Engineers Comments Regarding Surface Water Drainage

Application Reference:	BE/146/25/DOC	Reviewer Reference:	ADC/EXT5/AF
Planning Officer:	Amber Willard	Date of Review:	15/01/2025
Site Name:	The Cottage Shripney Road Bognor Regis PO22 9PA		
Application Description:	Approval of details reserved by condition imposed under BE/176/21/PL relating to condition 26-surface water drainage.		
Assessment Number:	1

Condition 26: **Objection**

Comment 2: Flow control device evidence.

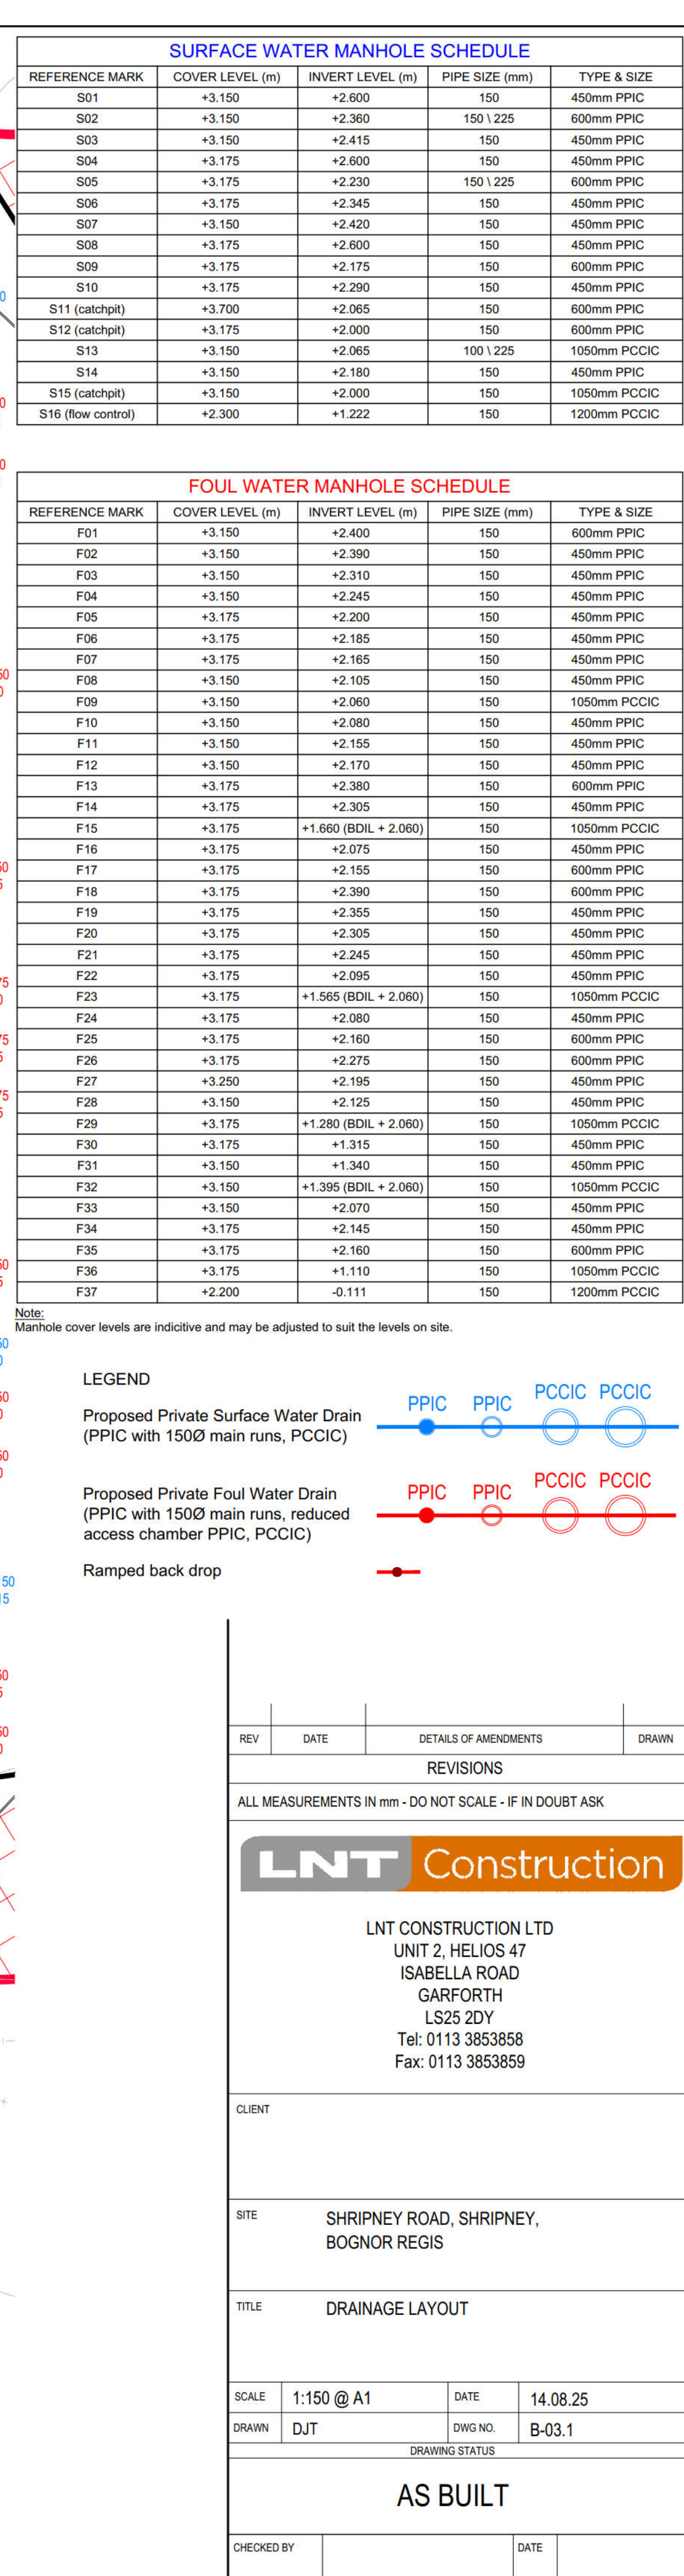
ADC Drainage Comments	Designer Response			
Date:	15/01/2025				
Condition Number: 26					
Comment Number					
1.	The swale, culverts and headwalls should be evidenced to be completed and installed in accordance with the approved plans by photograph.				
2.	The Flow control device should be evidenced to be installed in accordance with the approved plans including IL, type and product reference.				
3.	Site receipt tickets should be provided for the correct quantum of attenuation crate to support the site photos. Alternatively, survey or coordinates can be provided to confirm the plan area of the completed installation.
